NSW Department Primary Industries  
Crown Lands  
T 02 6591 3526 F 02 6552 2816  
E [jaimie.vlastuin@lands.nsw.gov.au](mailto:jaimie.vlastuin@lands.nsw.gov.au)

File No: 07/2244 & DOC11/091271  
Your Ref: 09\_0019  
15 August 2011

**RE: ENVIRONMENTAL ASSESSMENT EXHIBITION: MAJOR PROJECT 09-0019 – RIVERSIDE TOURIST CABINS, NEW ENTRANCE ROAD, SOUTH WEST ROCKS.**

<b>Application No.</b>	09_0019
<b>Location</b>	Lot 4 DP 1022342 New Entrance Road South West Rocks
<b>Proponent</b>	Shannon Pacific Pty Ltd
<b>Council Area</b>	Kempsey
<b>Approval Authority</b>	Minister for Planning and Infrastructure

TITLE
**PREDICTED
TIDAL FLOW
INUNDATION
LEVELS**

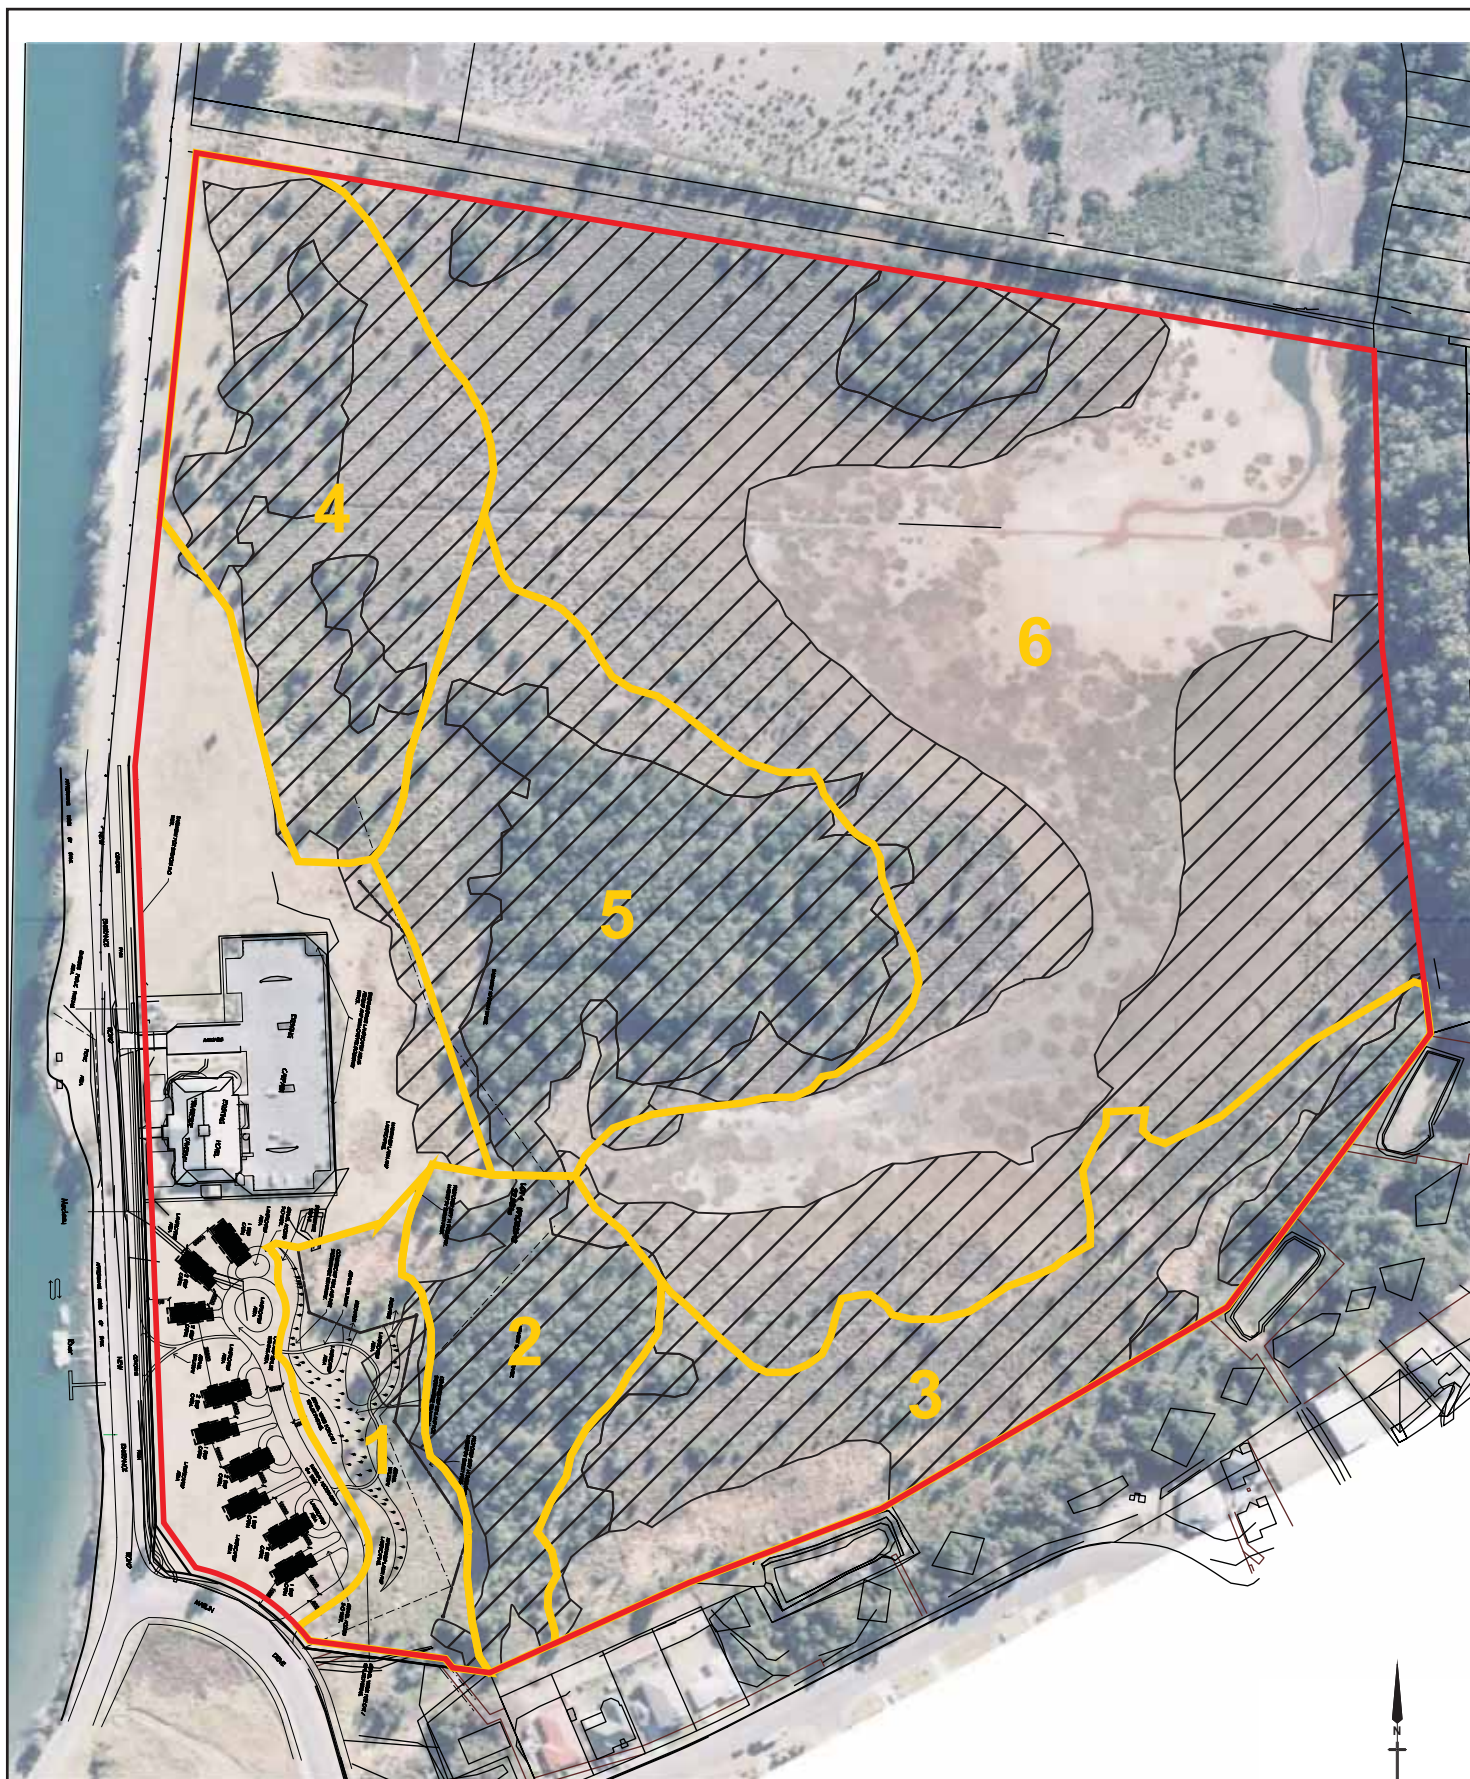
Whilst the restoration of tidal flow to the site is likely to be an environmentally beneficial project in long term if undertaken appropriately, there are concerns with restoring tidal flow to wetland areas that have been 'drained'. This is particularly relevant when a site is impacted upon by Acid Sulphate Soils or Potential Acid Sulphate Soils. Management of such sites require careful consideration.

Crown Reserve 86006 is downstream from the proposed development site and proposed flood gate. Hence the Crown Reserve could be directly adversely impacted by the proposal due to a possible increase in acid water, particularly in the early stages of restoring tidal flow.

The Environmental Assessment and Proposed Monitoring Programs need to include impacts on lands downstream of the flood gate, including the Crown Reserve.
